Online Comment

Application H16-1086-15
Location Land adjacent 76 Bourne Road Spalding PE11 1JR
Proposal Residential development

Name Spalding & District Civic Society
Address 19 Ladywood Road Spalding PE11 2DA

Site Block Plan

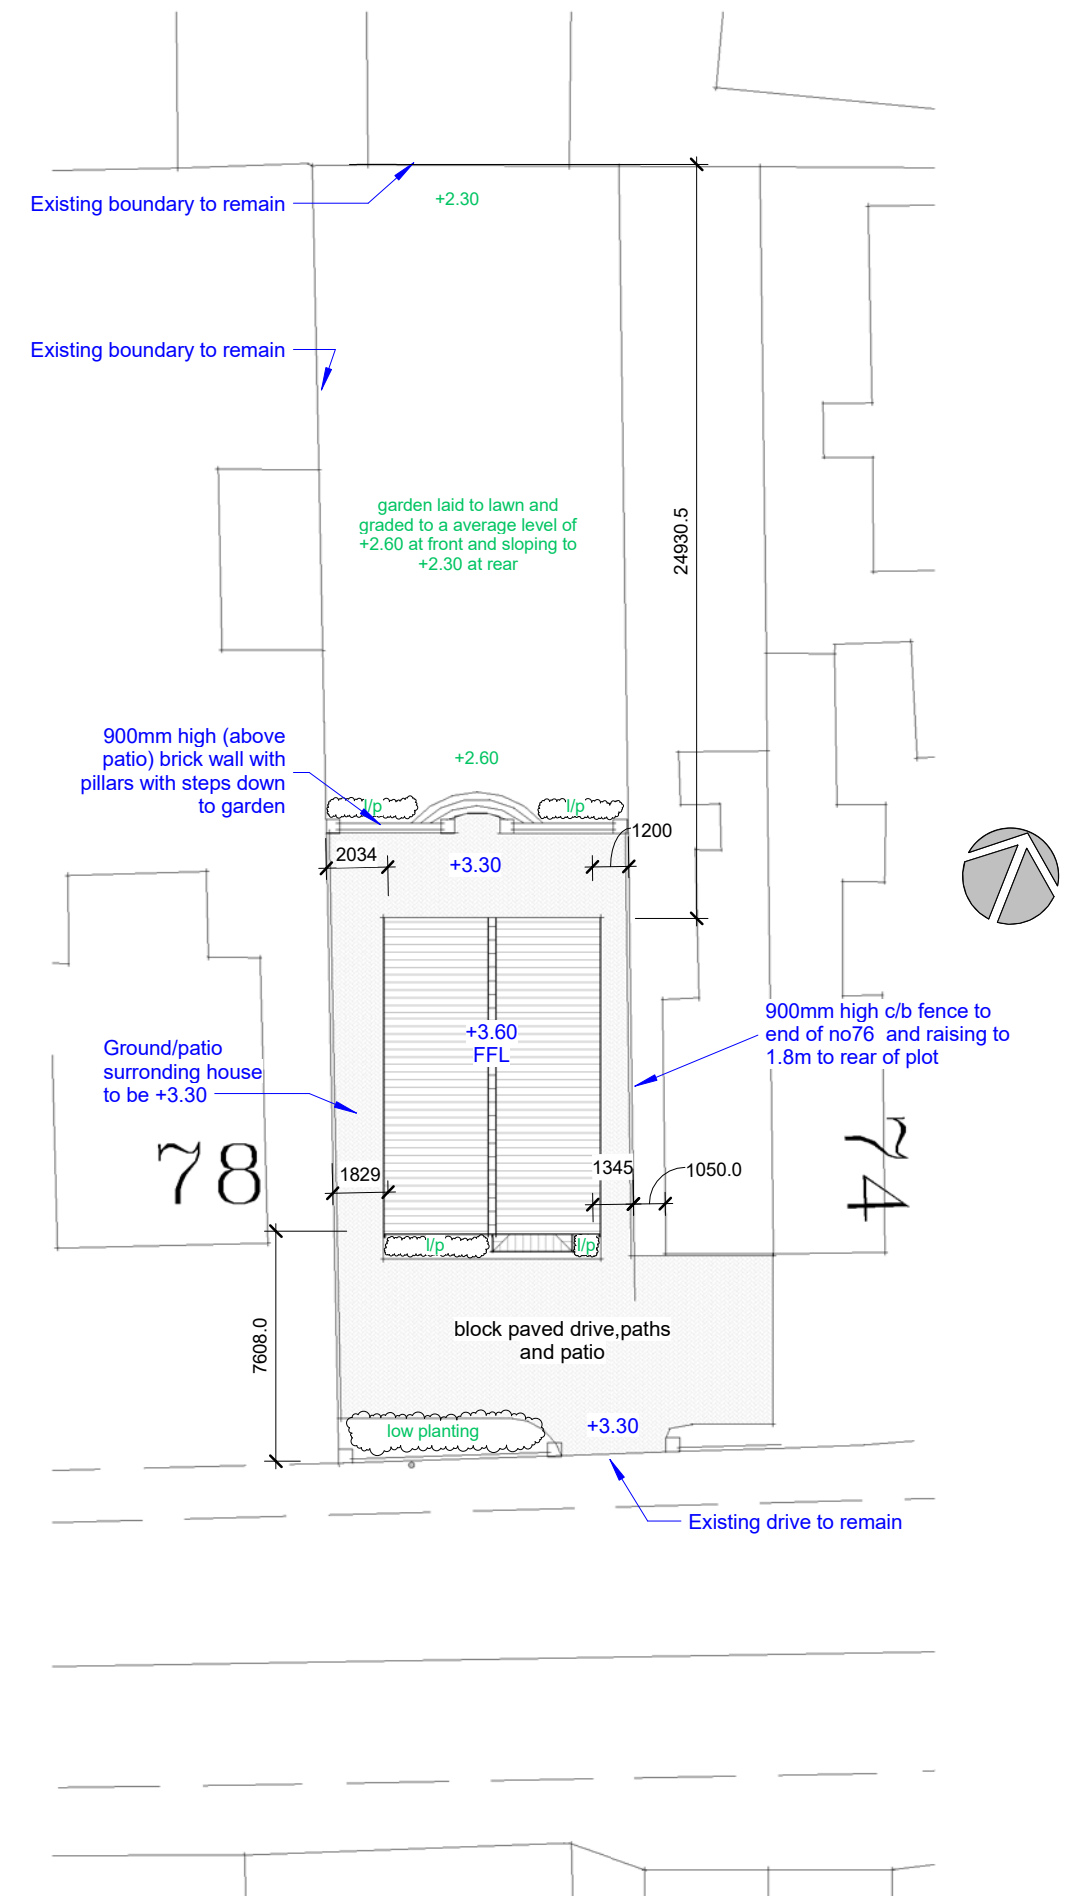
We are concerned about the difficulty of vehicular access to the site because of the significant difference in height between the busy main road and the site.
